Our Case Number: ABP-319866-24

Re: Proposed development known as North Irish Sea Array ("NISA") Offshore Wind Farm
Located off the coast of Counties Dublin, Meath and Louth (www.northirishsearraysid.ie)

Marine Application Observation

Description: Proposed development known as North Irish Sea Array
("NISA") Offshore Wind Farm
(www.northirishsearraysid.ie)

# Figures for Chapter 30 Noise and Vibration

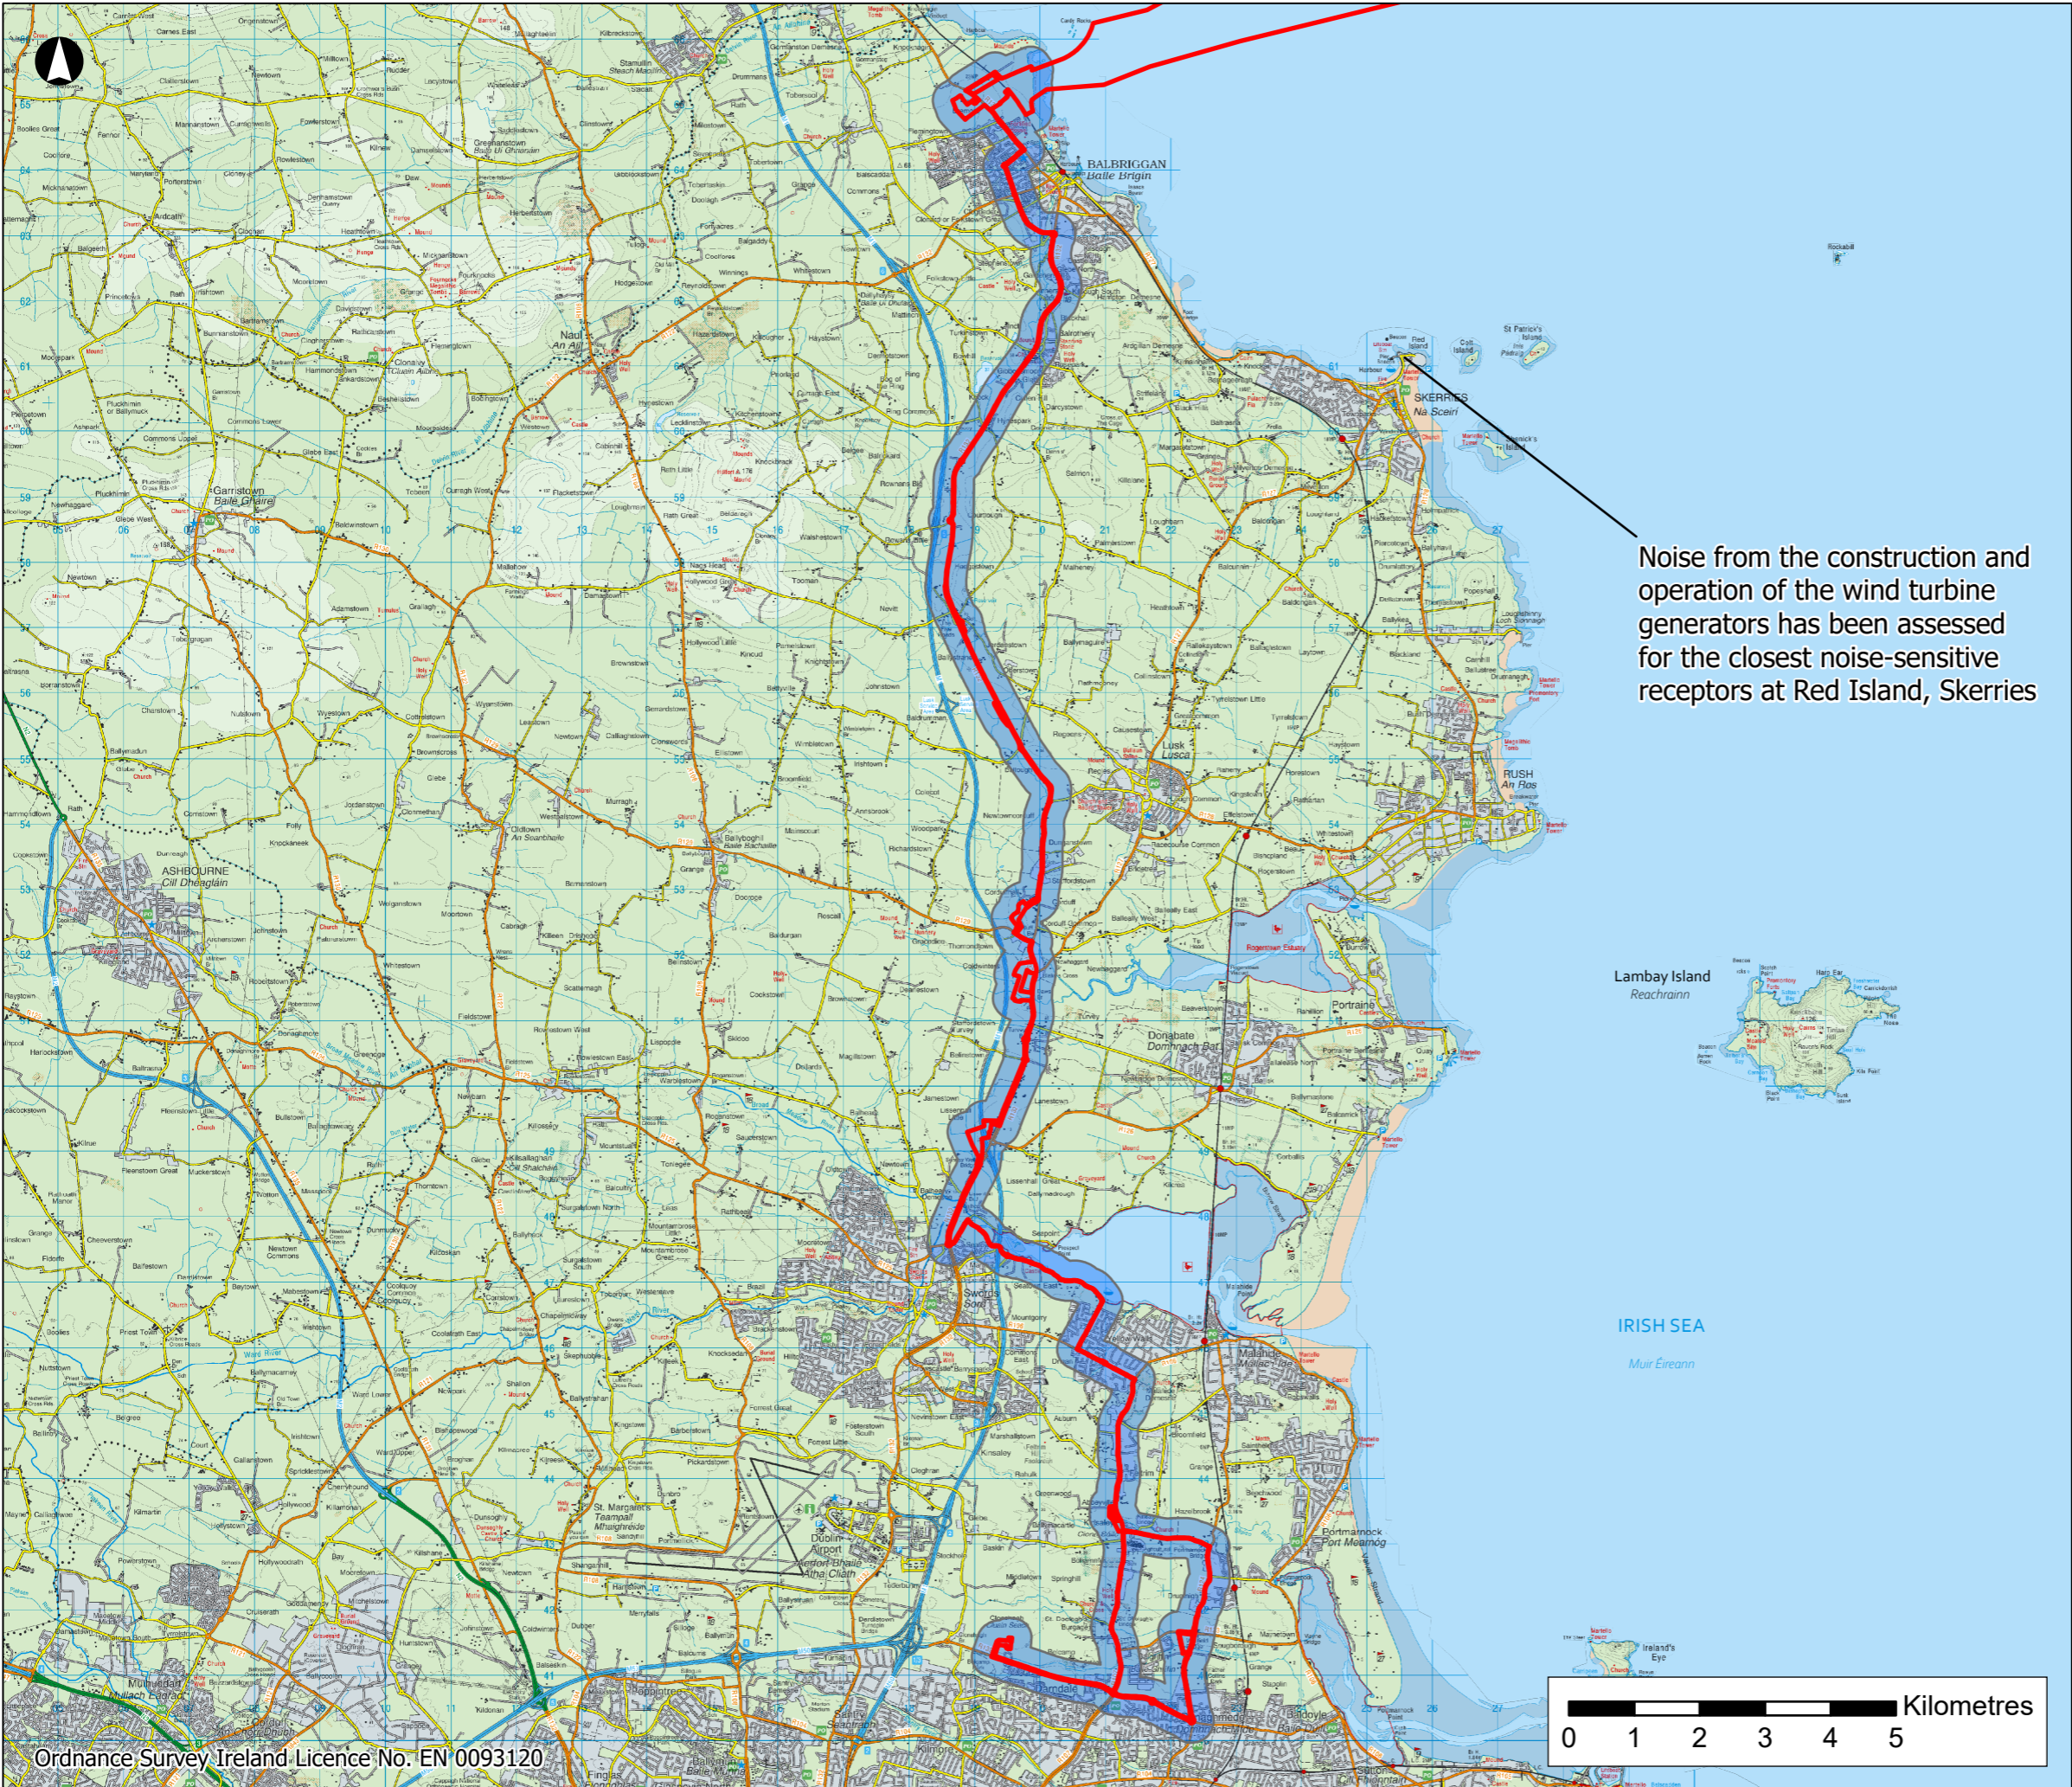
The Environmental Impact Assessment Report (EIAR) submitted with the application is incomplete and does not adequately describe the effect of airborne noise on the environment. Further information should be provided by the developer.

Specifically, Volume 5, Wider Scheme Chapters, Chapter 30, Noise and Vibration, Section 30.5.7.1 states that 'a noise source sound power level of 115 dBALw for each WTG – a source representative (sic) of a large offshore WTG of the type proposed...'

- a. Present the method of calculation used for wind turbine noise.
- b. It does not present any supporting documentation for the sound power level (source level) of the wind turbines. A 'representative' level could mean anything.
- c. The EIAR does not state whether any uncertainty factor (as good practice would require) has been used in the calculations.

It is not possible to test or verify the modelling used or the results obtained without this information. The Board is being asked to accept a result (unsupported by any evidence) on an important impact which cannot be verified. If the Board cannot verify the calculation it could be considered a lacuna in their assessment.

- a) Maximum sound power level data for all the candidate turbines proposed in the EIAR in octave bands from 63 Hz to 8000 Hz at a range of wind speeds;
- b) The cut-in wind speed of the candidate turbines;
- c) The wind speed at which the candidate turbines reach maximum output;
- d) The cut-out windspeed of the candidate turbines;
- e) The maximum sound power level data of the candidate turbines from the cut-in wind speed to the wind speed they reach maximum output at 1 m/s intervals; and
- f) A declaration as to whether the sound power levels are WARRANTED sound power levels or not.
